**PREFERRED PROJECT REPORT  
MP 10\_0107**

**61 MOBBS LANE, EPPING – STAGE 1 TOWNHOUSE  
DEVELOPMENT**

**NOVEMBER 2010**

Project Application  
 A-3103

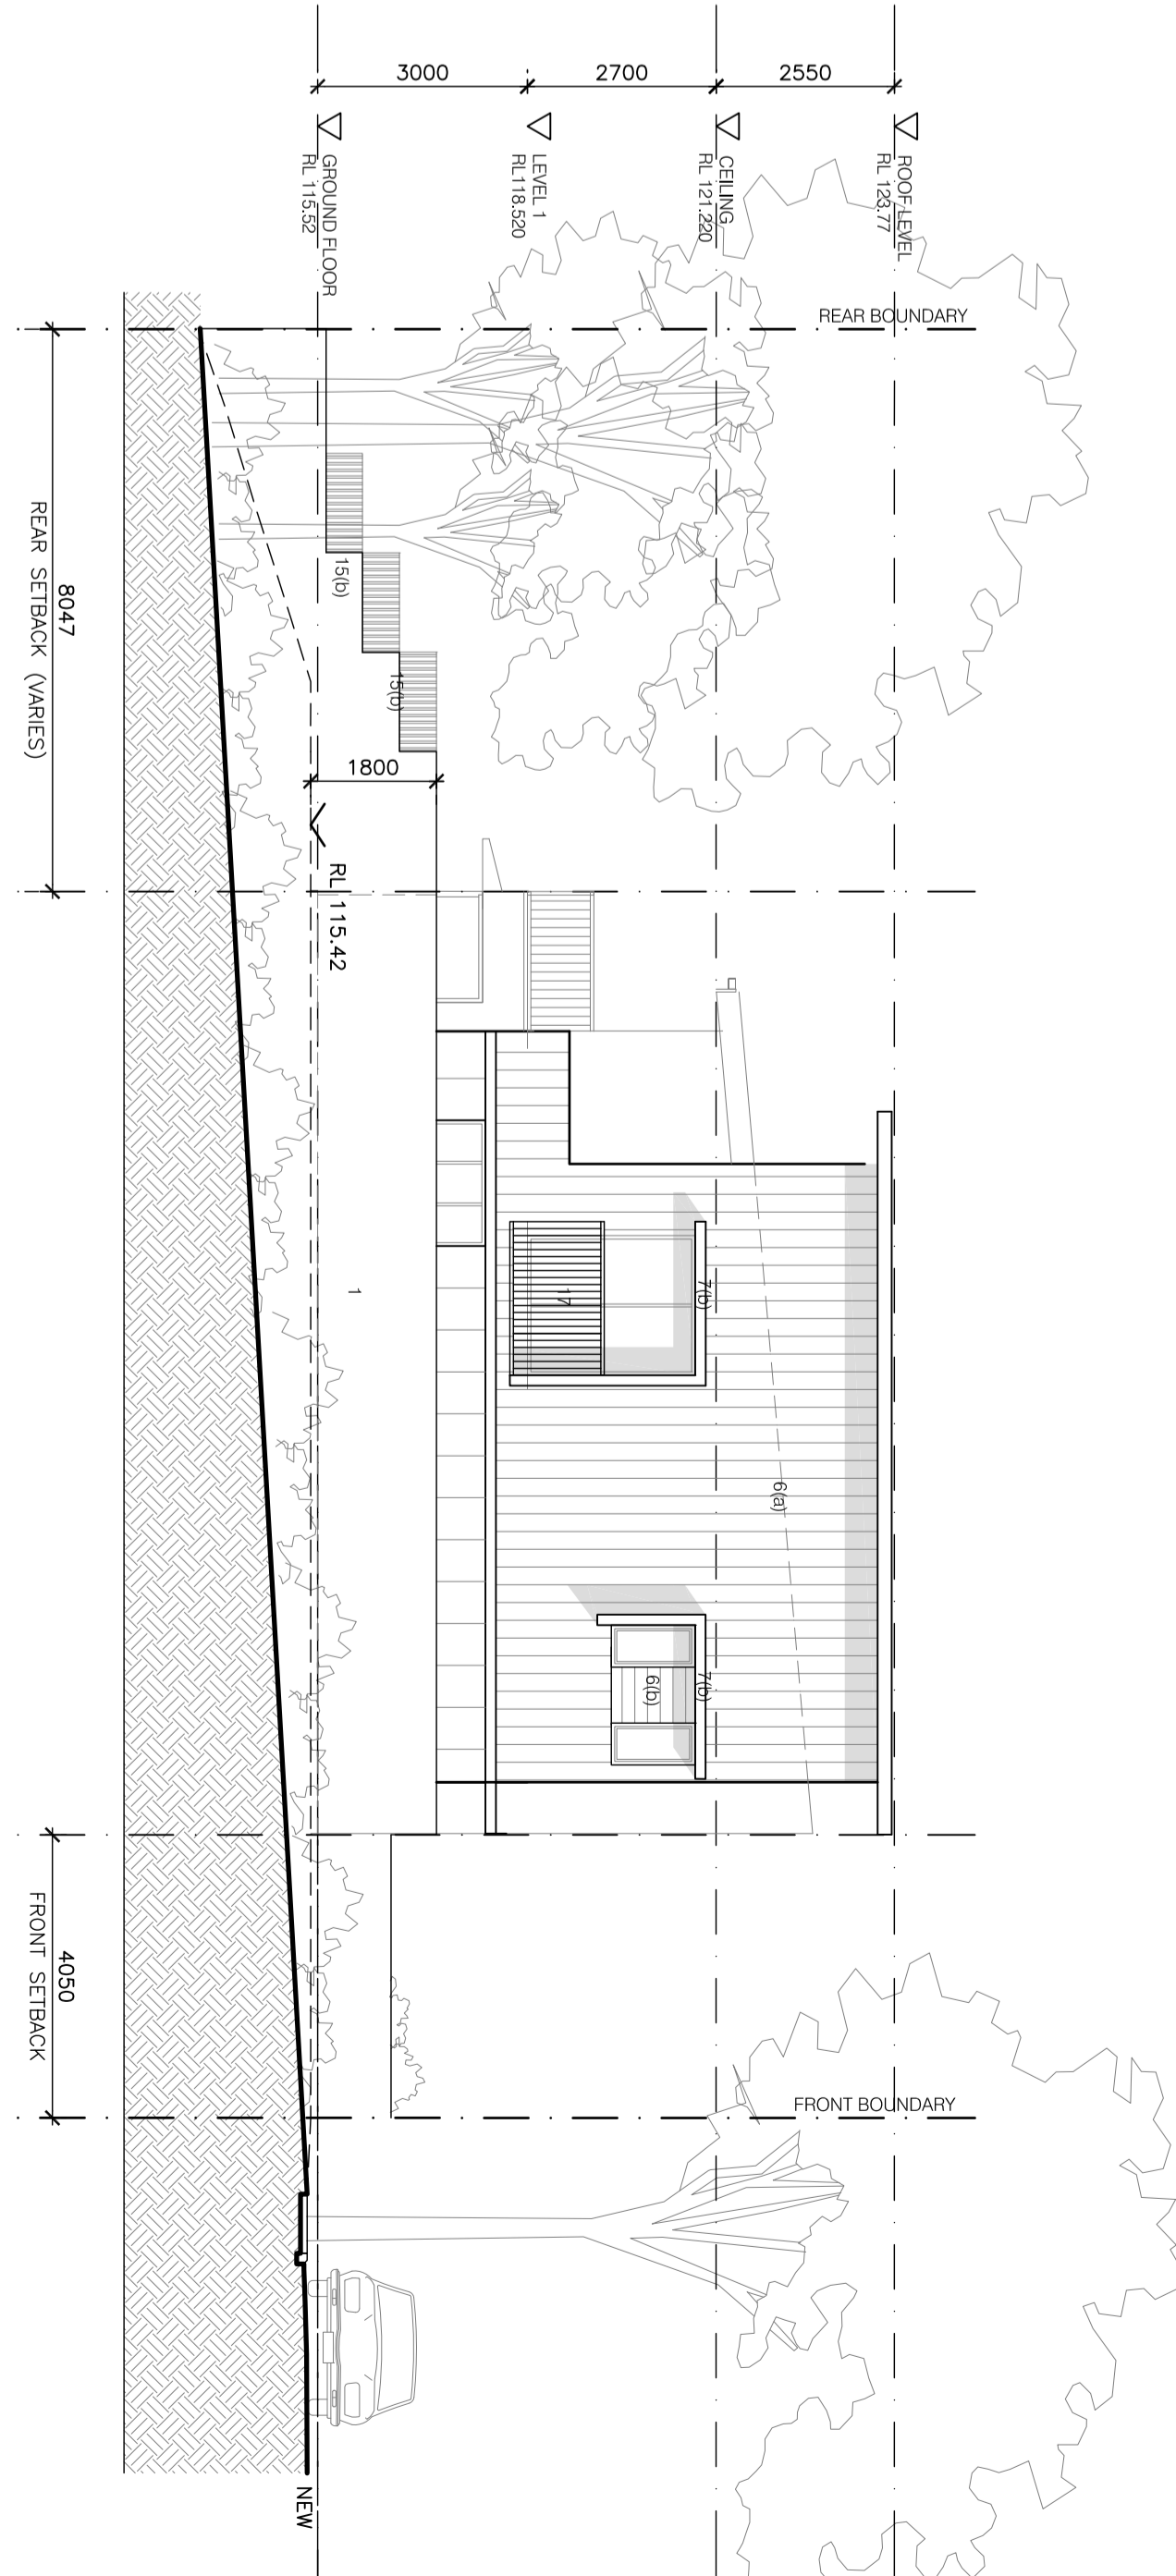
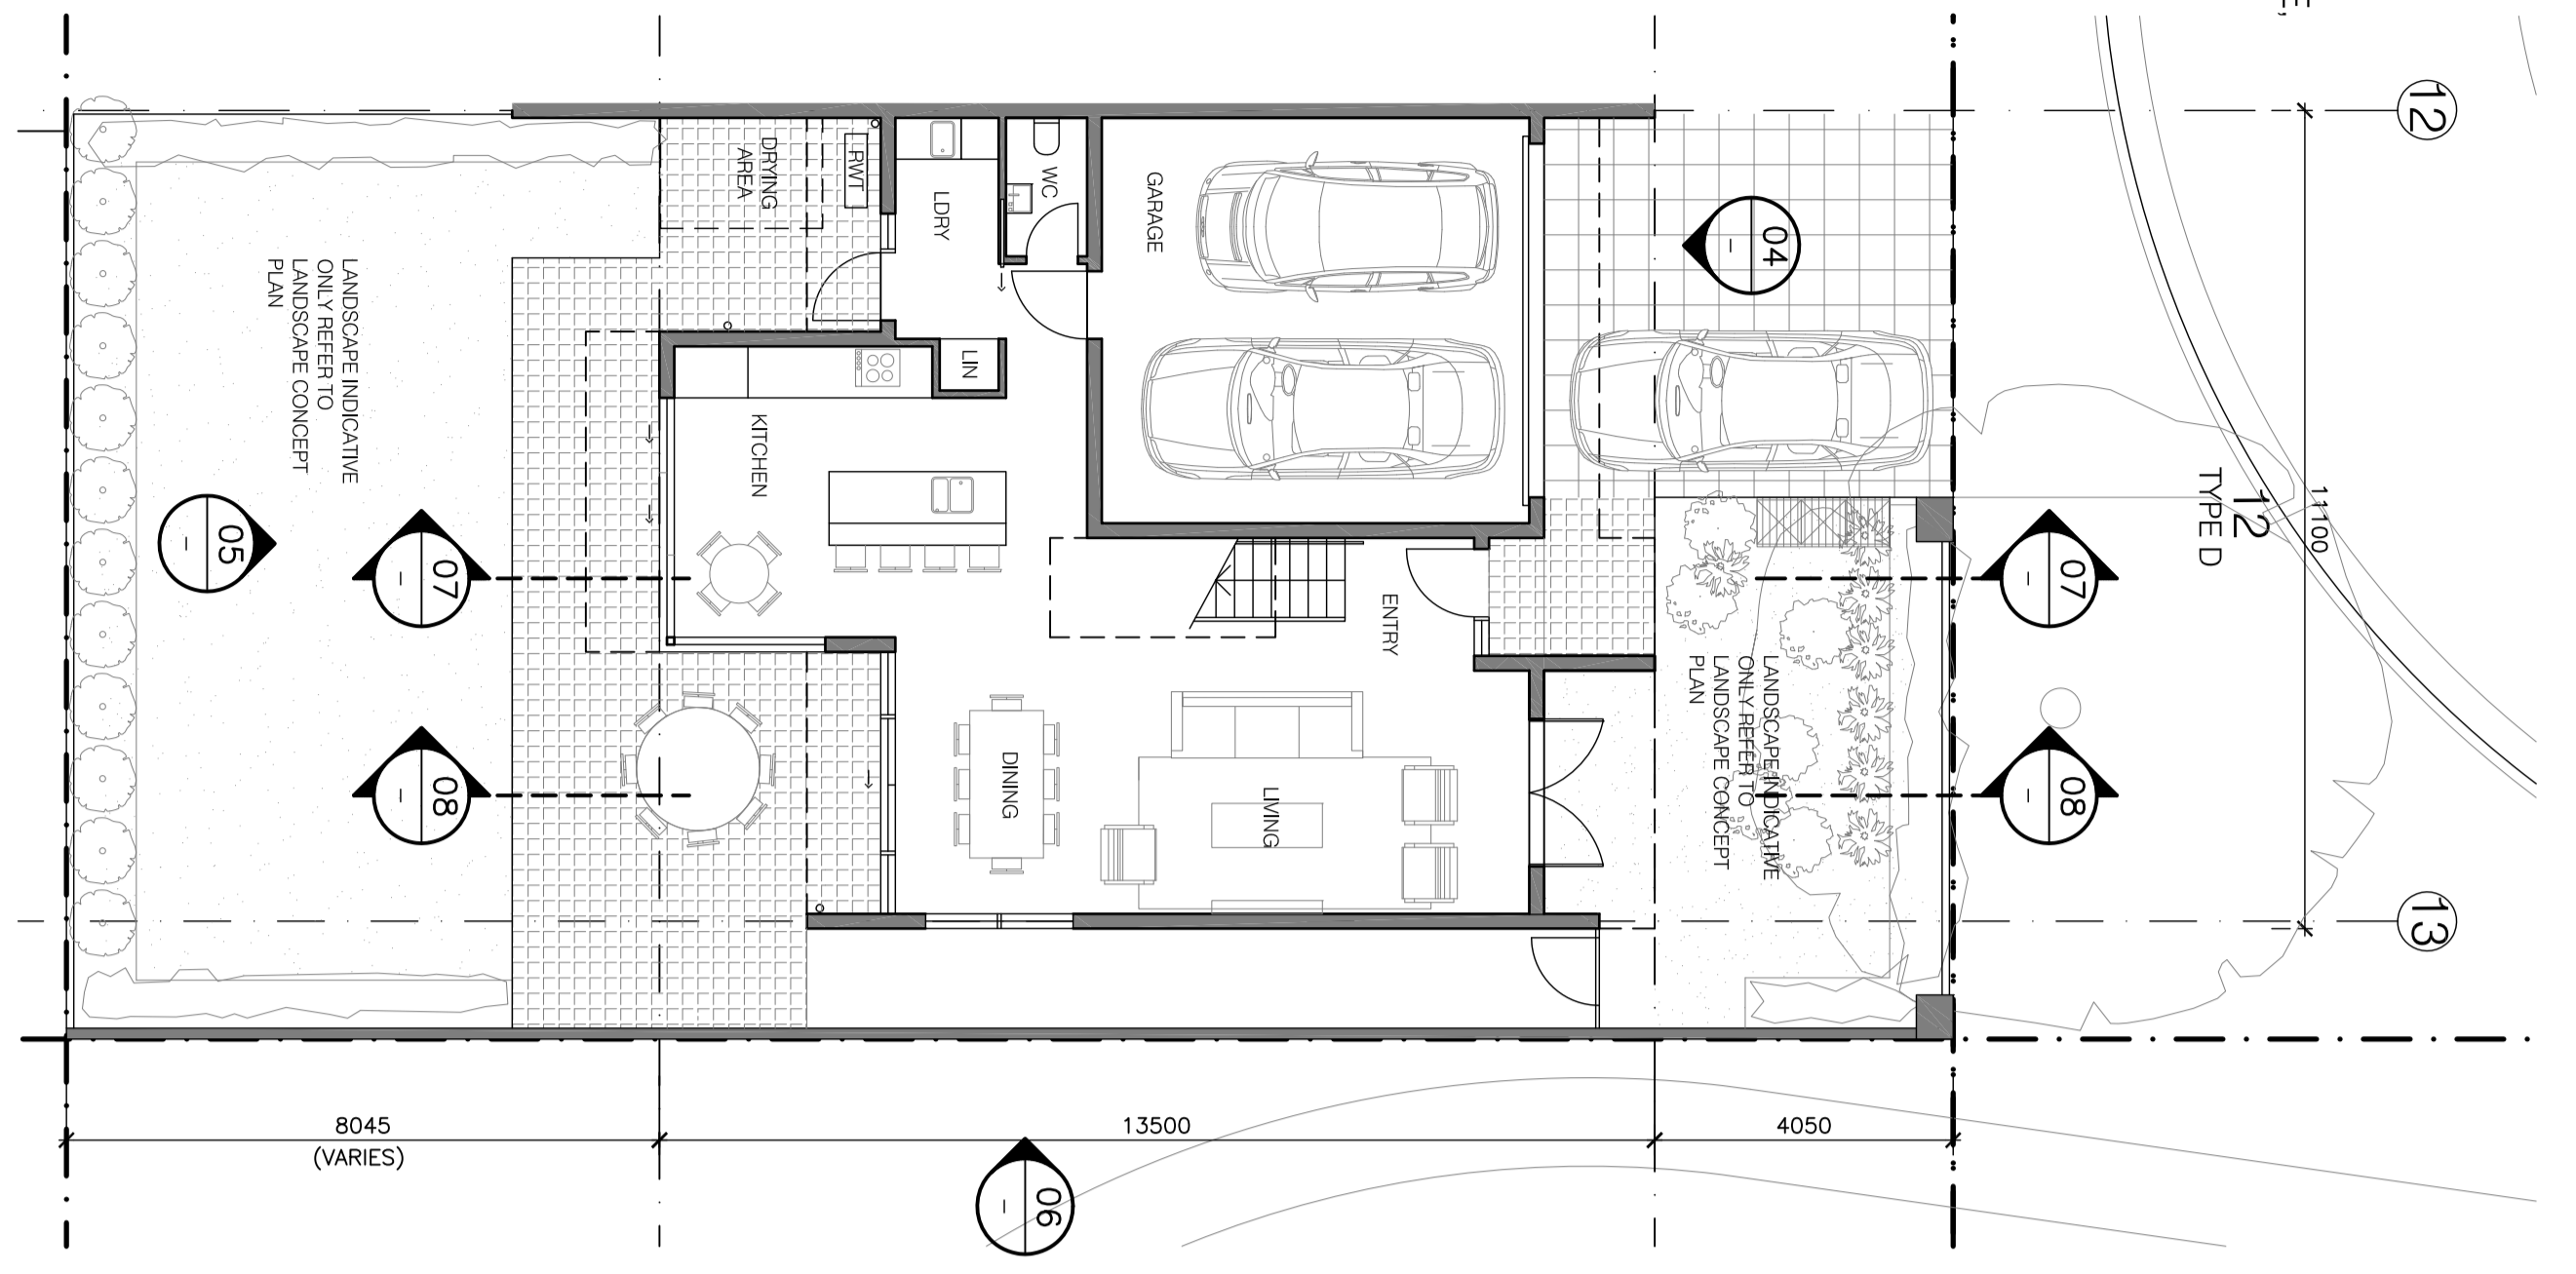
Issue: Private Open Space: The front fence should be a max. of 1.2m in height, 40m<sup>2</sup> per dwelling of private open space is required and no front yards are permissible

Response: The private open space is located to the rear of the dwelling to ensure that the space is private and useable. The front fences will not exceed 1.2m, as per the submitted architectural plans and the rear yards provided in building 3 are substantially in excess of 40m<sup>2</sup>. The size of the rear yards range from 106 – 187m<sup>2</sup>. Refer to **Annexure 1** which contains a schedule of areas for the rear yard.
